**Minutes from meeting dated 3<sup>rd</sup> June 2009 (2:30pm – 4:00pm)**  
**MERITON ARNCLIFFE, BONAR ST**

Councils Floodplain and Stormwater Engineer (Tony Merrilees) has reviewed Hughes Trueman's DA report (March 2009) and issued comments accordingly (DA-2009/307). In particular, the flood study was discussed in Section 8(b). These items were discussed in the meeting marked "Flood Study Items" as mentioned below.

**Minutes from meeting dated 30<sup>th</sup> July 2009 (10:30am – 12:00pm)**  
**MERITON ARNCLIFFE, BONAR ST**

Figure 4.1 – DRAINS Network

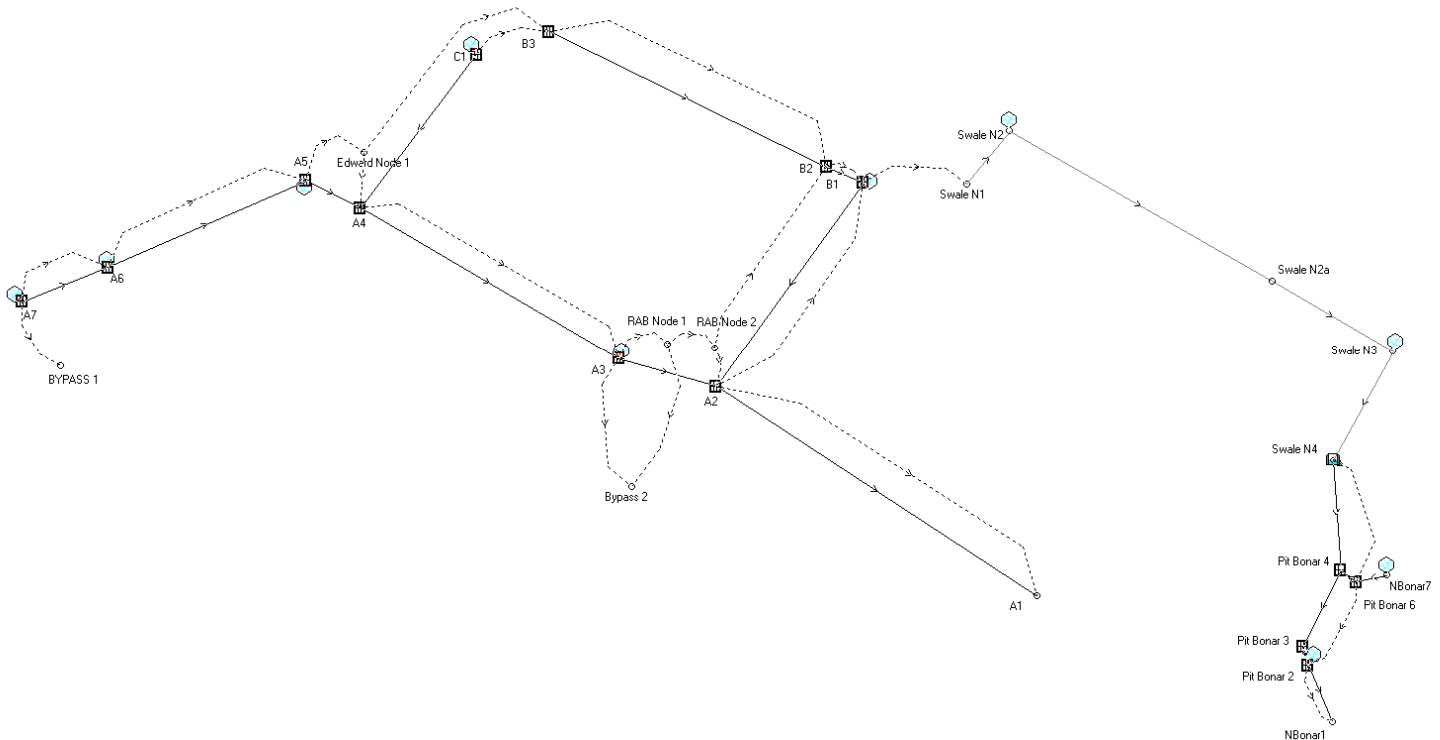
- CR presented both the revised catchment plan and roundabout contours which were used to model 100yr surface flows to Loftus St. Here CR explained the methodology used to determine the design flowrate at Loftus St through the development of an "unsteady" DRAINS model. Components of modeling discussed included:

- Cross sections and levels applied at roundabout to determine flow splits using unsteady modeling;
  - Revised results of 3.16m<sup>3</sup>/s at Loftus Sag (refer to comments below)

- TM stated that methodology and modeling seems acceptable. However would like HT to check the following:
  - Impact which sag in Edward St may have on flows along Hirst St (That is, surface flows which may enter Edward from Hirst St, pond and then continue along Hirst St or flow through the Edward St properties to Loftus St and add to the flow in the swale)

- CR and TM agreed that sump pits could be provided and connected to the swale at a suitable point along the length (where surcharge would not occur from flows in swale).
